Planning Application Ref: AW/70/19/T

Location: Holly Lodge, 3 Barrack Lane, Aldwick, PO21 4BY

Description of works: Crown lift by 1m, Crown reduction by 3m & Crown thin 30% to 2No. holm oak trees. Crown reduction by 3m & Crown thin 30% to 1No. sycamore tree. Reduce split bough by 2.25m to 1No. holm oak tree

LOCATION PLAN.

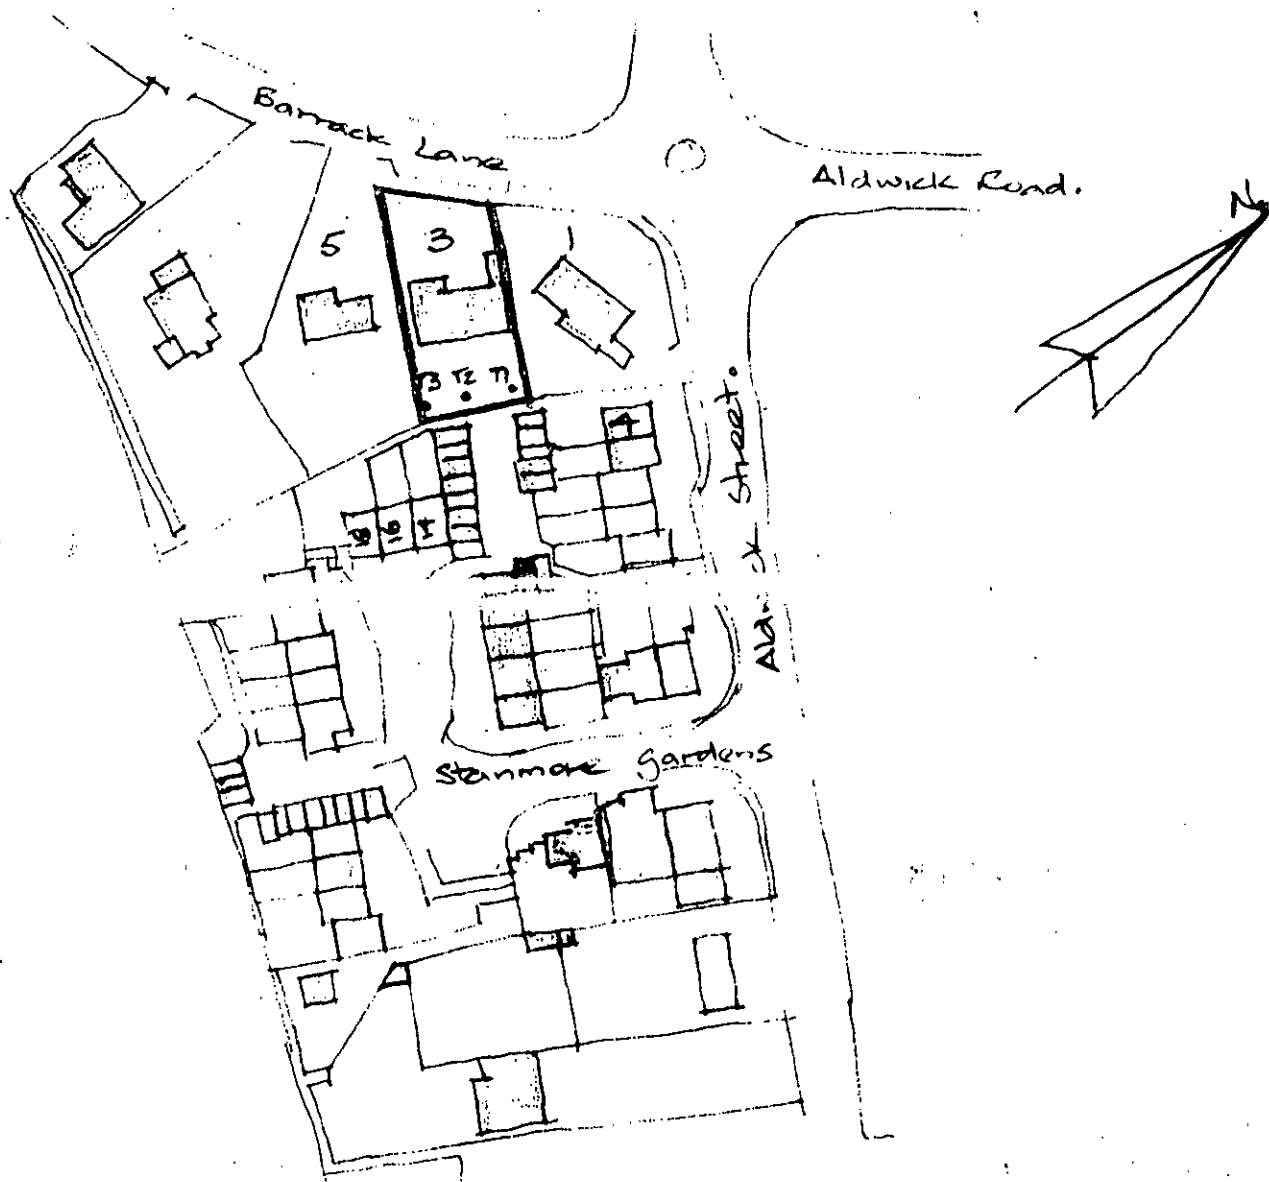
T1 & T3 Holm oak / <i>Quercus ilex</i>	Average height: 8m	Average spread: 3m	Age class: Early mature
T2 Sycamore / <i>Acer pseudoplatanus</i>	Approx. height: 10m	Average spread: 3m	Age class: Early mature

- For the purposes of reviewing this application; all three trees can be satisfactorily considered for generic comment, as follows:
- Outwardly and from a distance they appear to be healthy and stable. Despite their history of heavy and regular crown reduction they have 'grown-on well' (particularly T2) and their collective canopy makes a useful visual contribution. Canopy height, spread and overhead clearance is proportionate and not obviously problematic in relation to its surroundings.
- I did not observe a split limb/branch although my view was restricted to the eastern aspects. If such a limb presents an immediate risk of harm to person/property then it would qualify as an exception and does not require our consent prior to it being 'made safe'.

- Repeat crown reduction pruning operations will be necessary throughout the remaining life-span of these trees, to achieve a reasonable degree of structural integrity appropriate for their location. The proposal to reduce overall height and spread with a view to restricting their growth is consistent with previous applications (approved by the Local Planning Authority) although I find the timing of this latest proposal to be premature in the management cycle and likely to be harmful to the trees ongoing health and vitality. There is insufficient extension of new growth since the last major pruning operations (c2015).

- Crown reduction* and *Crown thinning* work has not been justified on arboricultural grounds. In respect of the latter, such work rarely provides a benefit to the tree and often only a short-term increase in light levels. Furthermore, such considerable loss of crown volume during a one-off operation will impose undue physiological distress and may compromise their long-term position in the landscape.

- I recommend **REFUSAL** for this application.

- I would recommend the applicant re-apply for the crown lifting and crown reduction elements of this application in 18-24months from now, at which time I would expect the subject trees to have achieved sufficient canopy renewal to sustain repeat operations.
